**26 Moody St - permit #2017-01260**

I have completed my initial zoning review for the permit to change the use of the building to a single family home. I have a few questions before I can sign off for zoning. It has been a little confusing because you have already been issued two fast track permits. It is a little hard to tell where the work approved under permit 2017-01281 ends and the work on this permit begins.

1 Proposed Site Plan

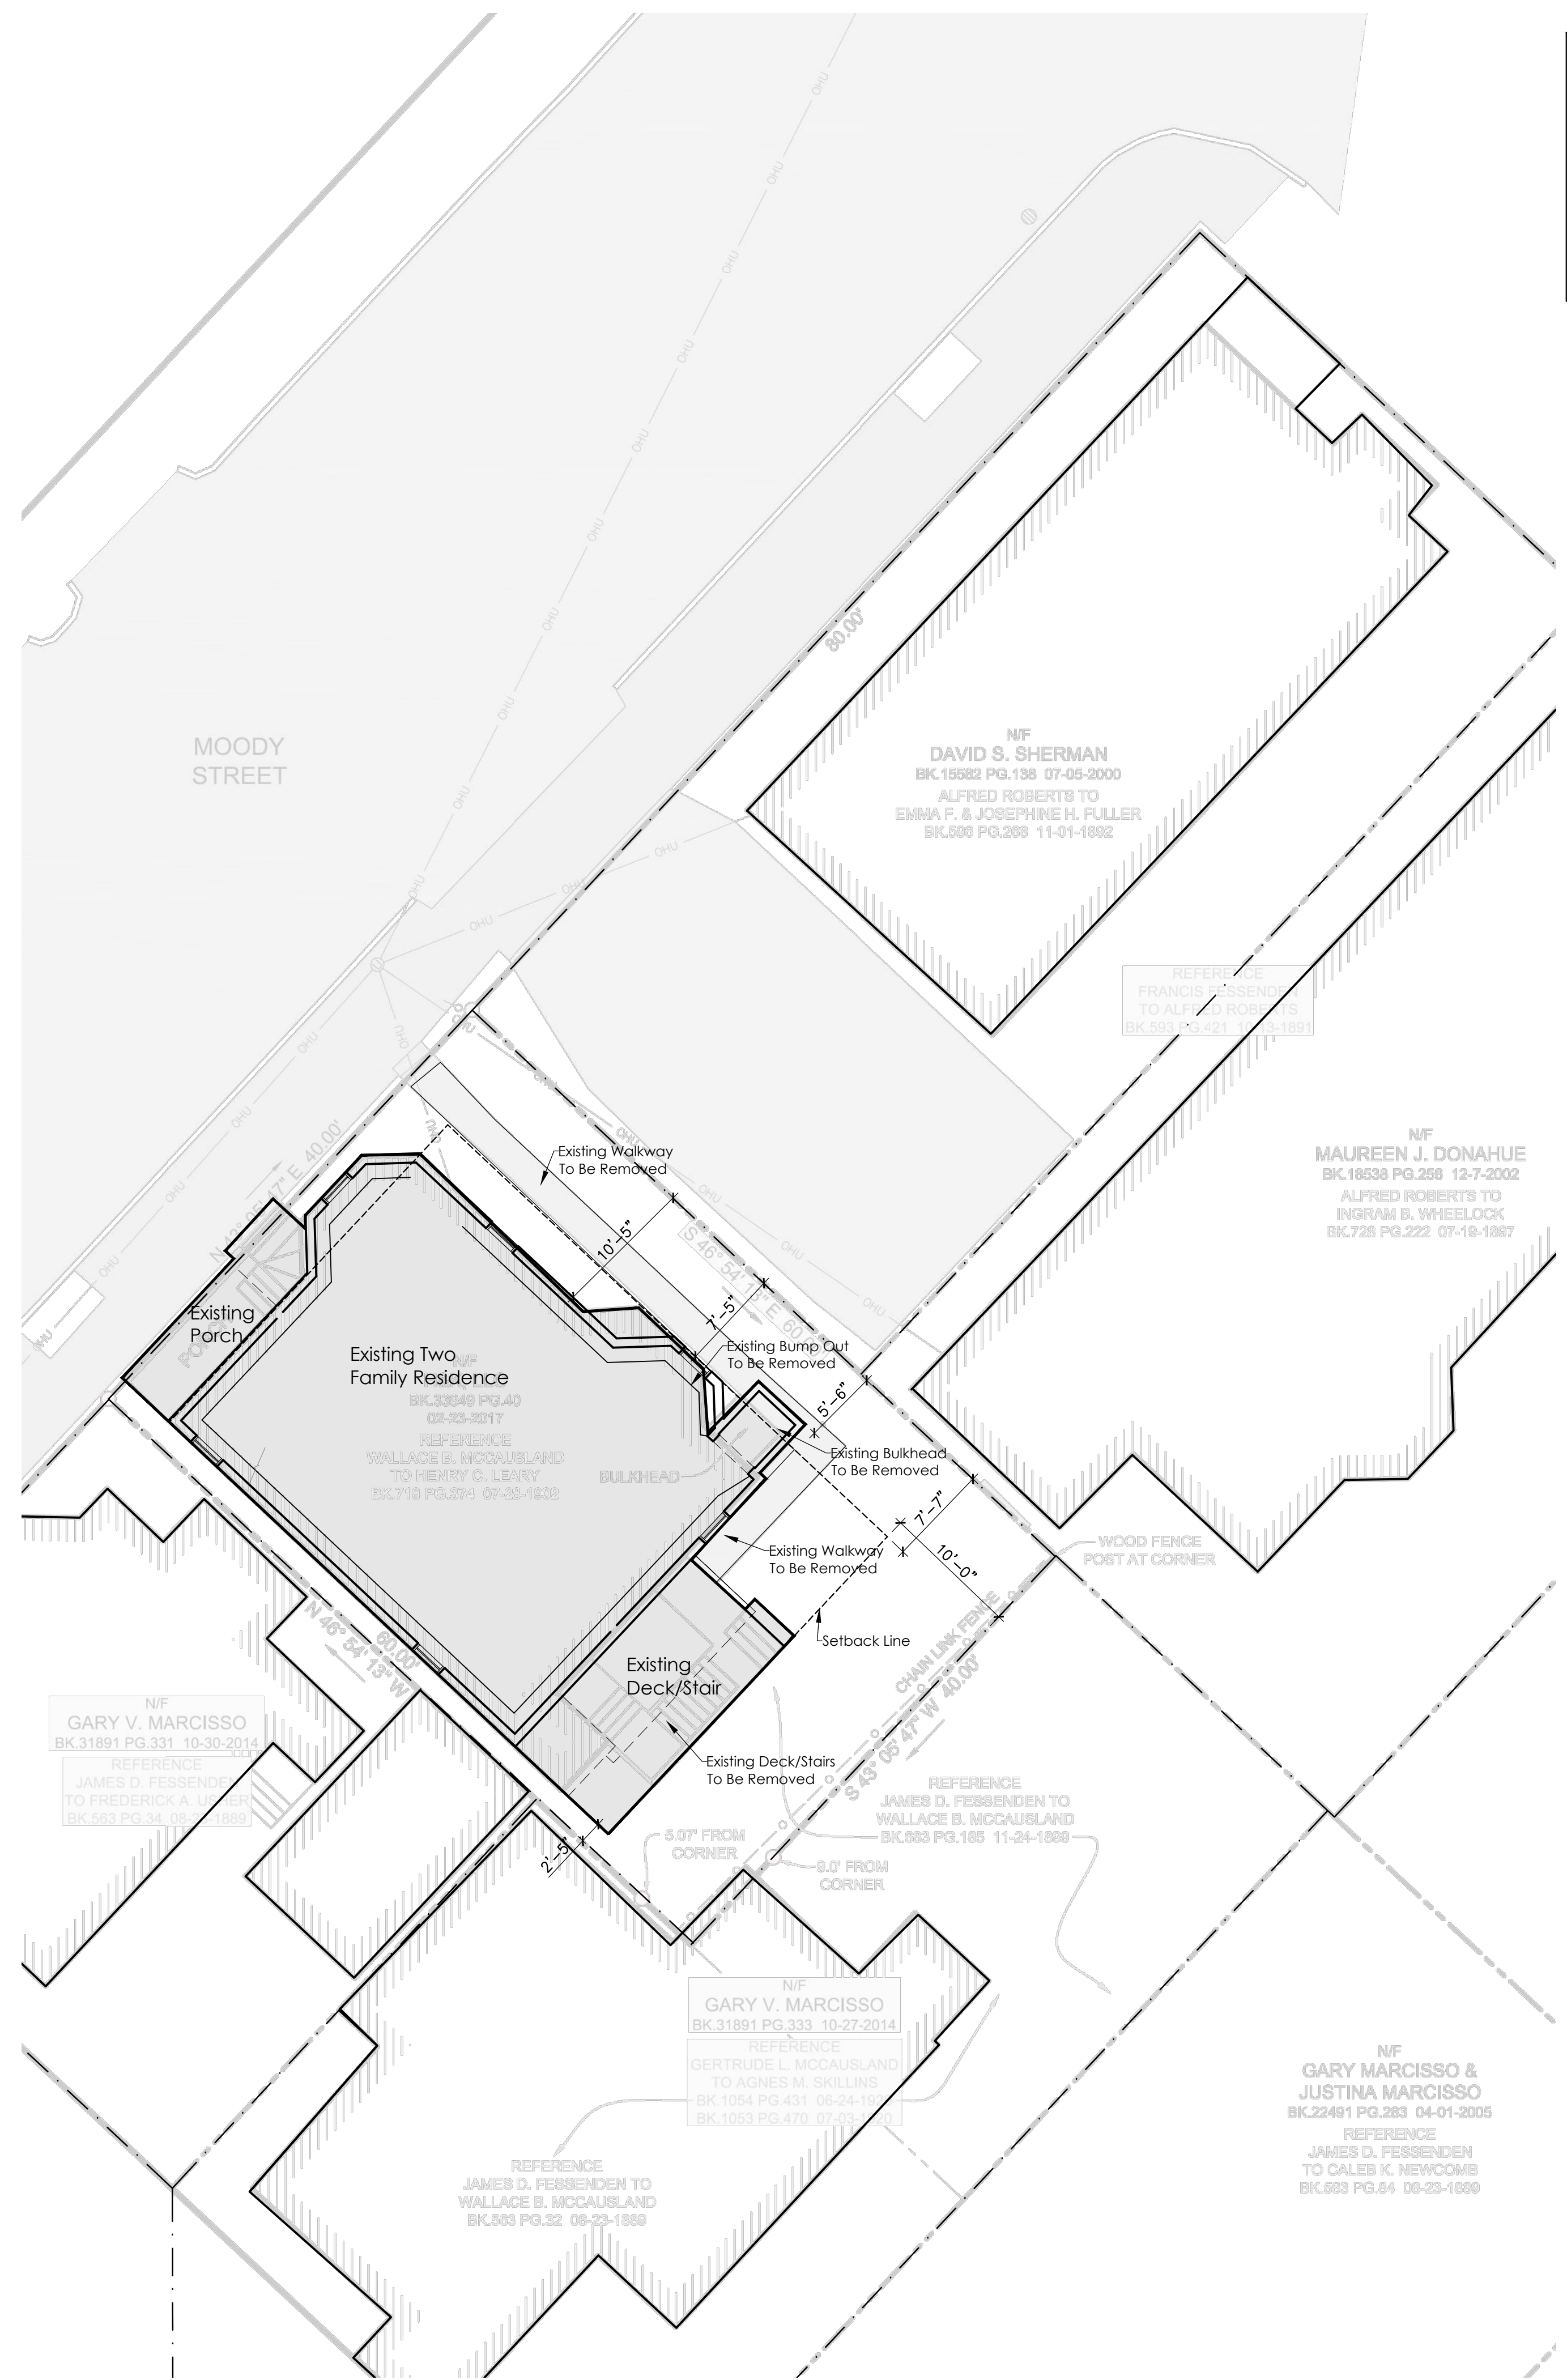
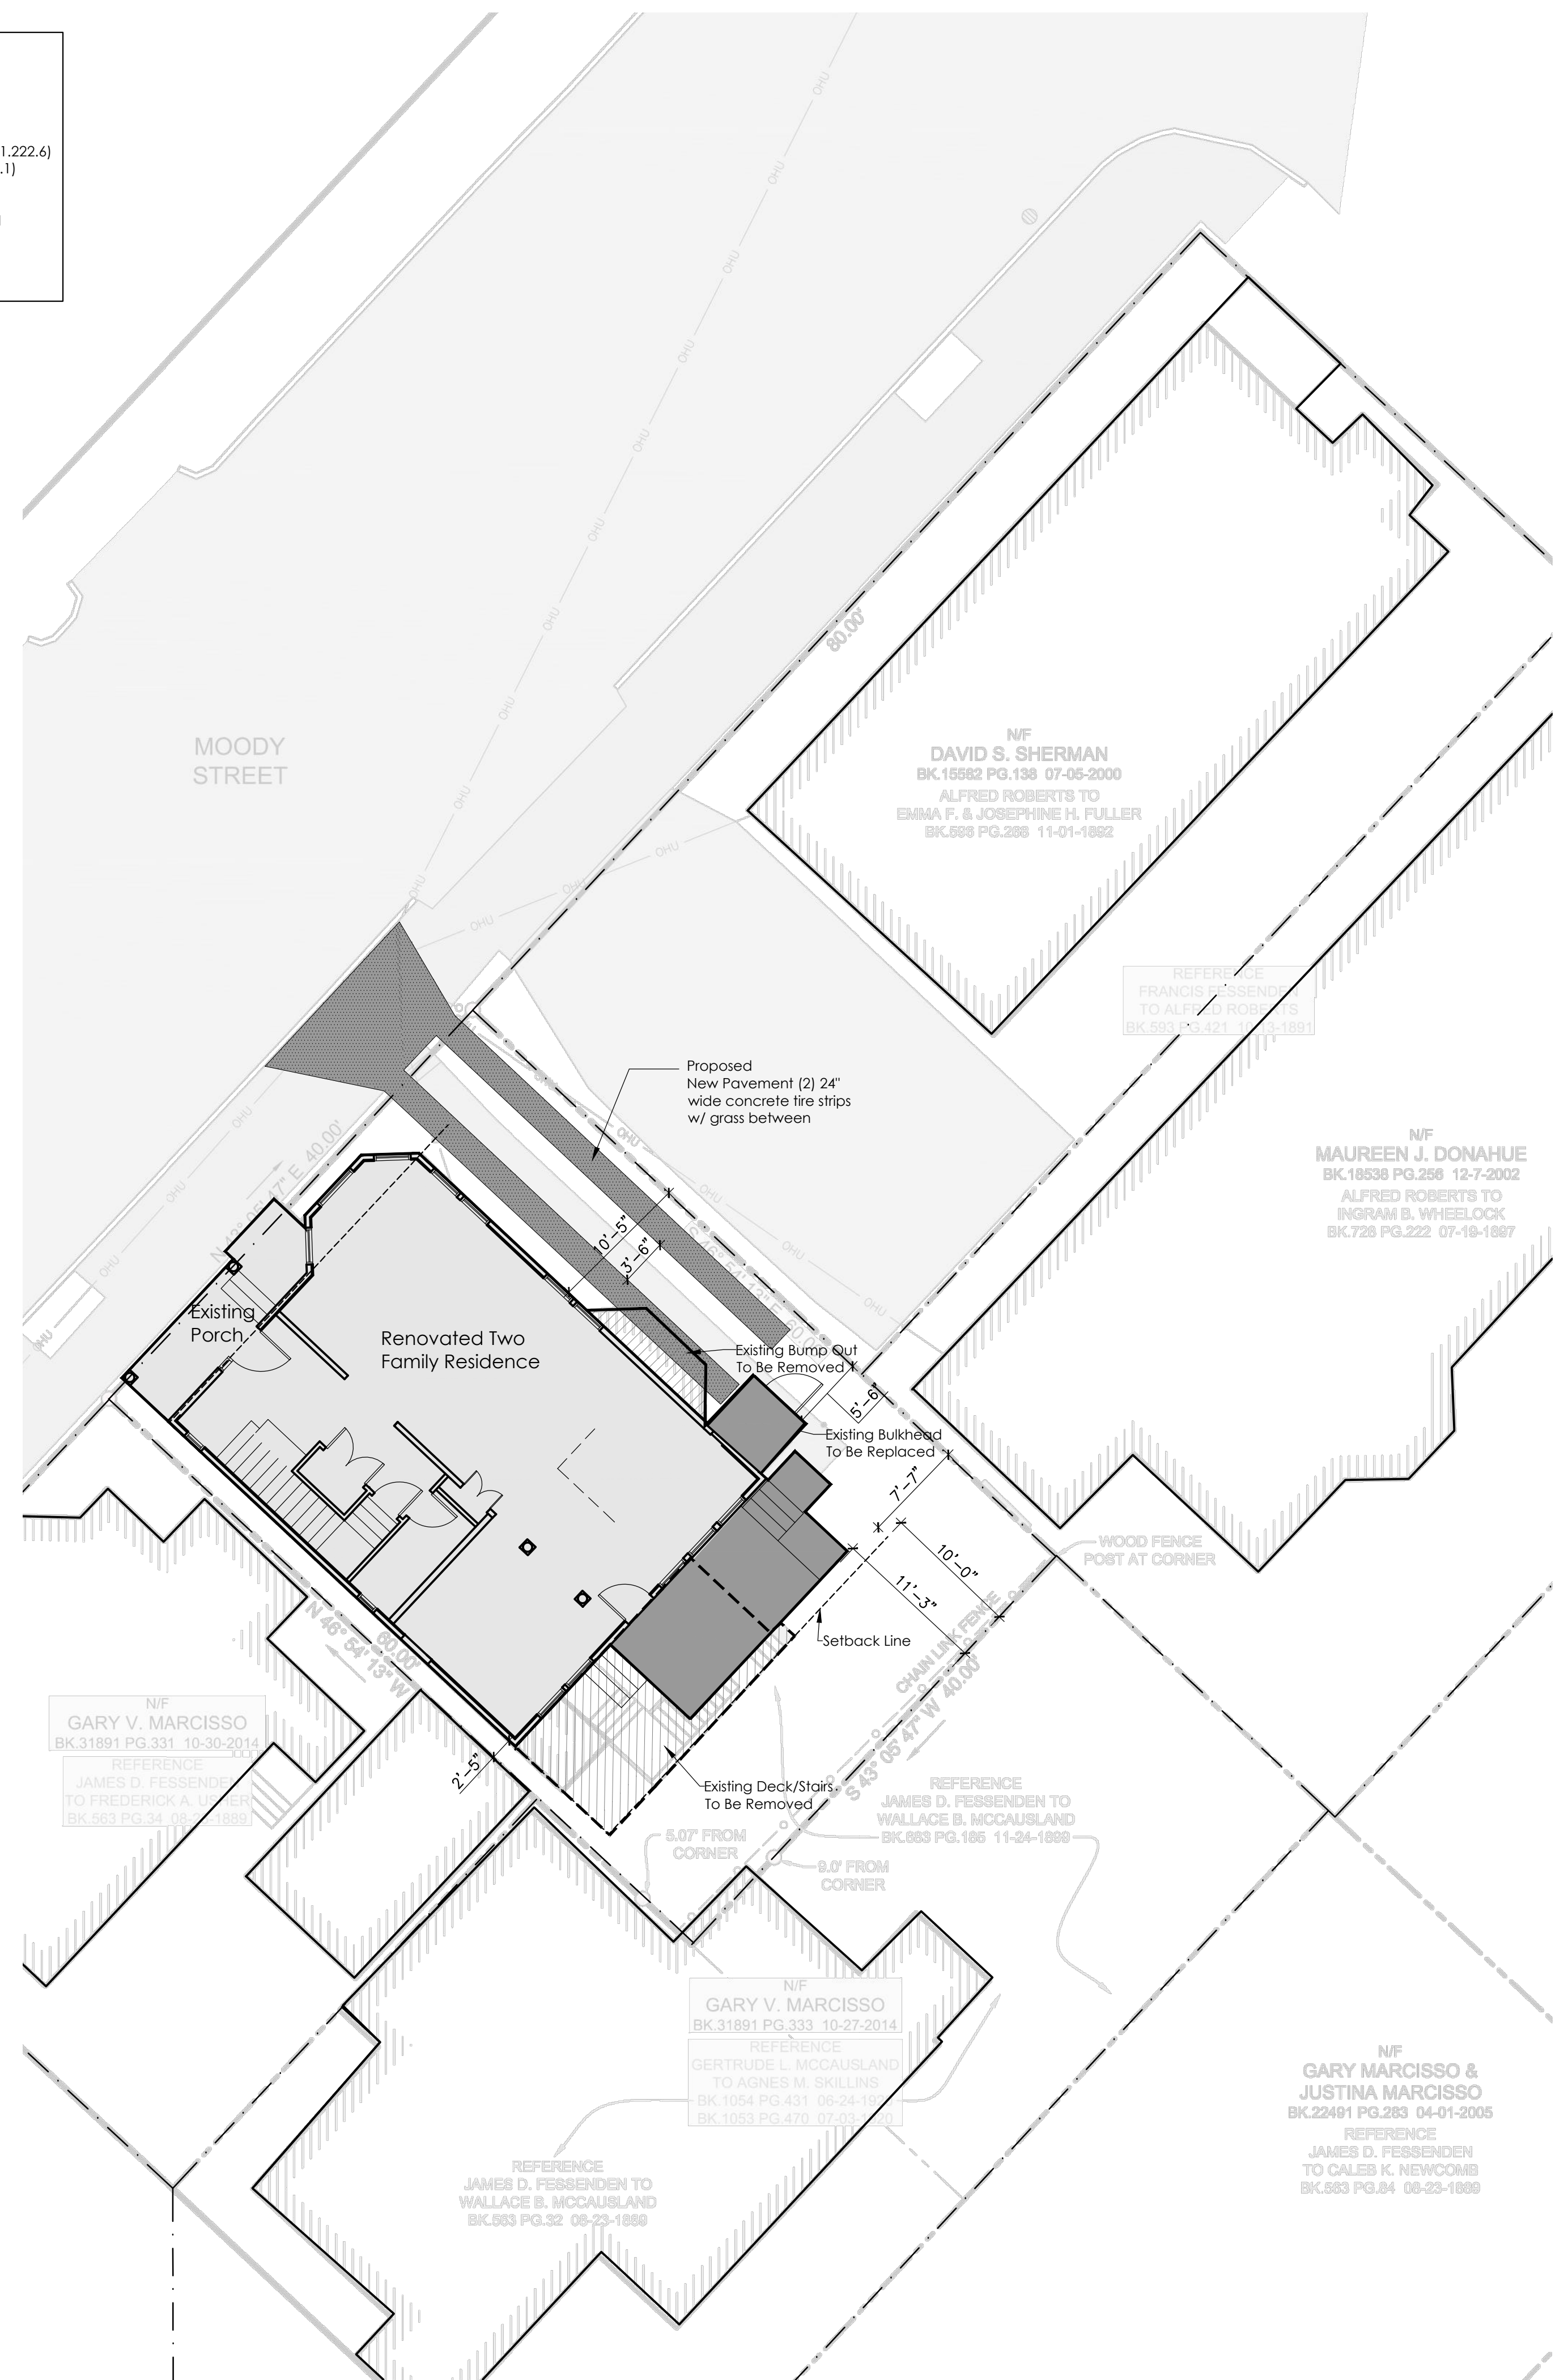
2. Is the attic going to be occupied or finished at this time?
3. I need some clarification about the new first floor deck. From plan A2.3 (South Elevation) and Plan A1.1 (First and Second floor Plan) the deck is 14' x 8' with a set of steps going off each side of it. The outline of the new deck on the proposed site plan is unclear. The gray area appears to show it but the gray area goes beyond the proposed stairs and it does not show the stairs on the other side going towards the right side property line.

4. The site plan shows a curb cut and driveway. There does not appear to be an existing curb cut. You need to work with Public Works to get a street opening permit if you want to install a curb cut.

- 1.) Yes to all - adding the deck over the front porch, the doghouse, and the rear deck, as well as moving windows and interior design.
- 2.) No, the attic will not be occupied, just roughed in for a future bedroom or other use.
- 3.) I believe the site plan does show both sets of deck stairs. You are correct there are a few areas of shaded gray that are somewhat confusing. I can swing by tomorrow if that would be helpful?
- 4.) The curb cut is complete. The permit for that was pulled by Ruck Paving. I believe I have a copy of that if you need it.
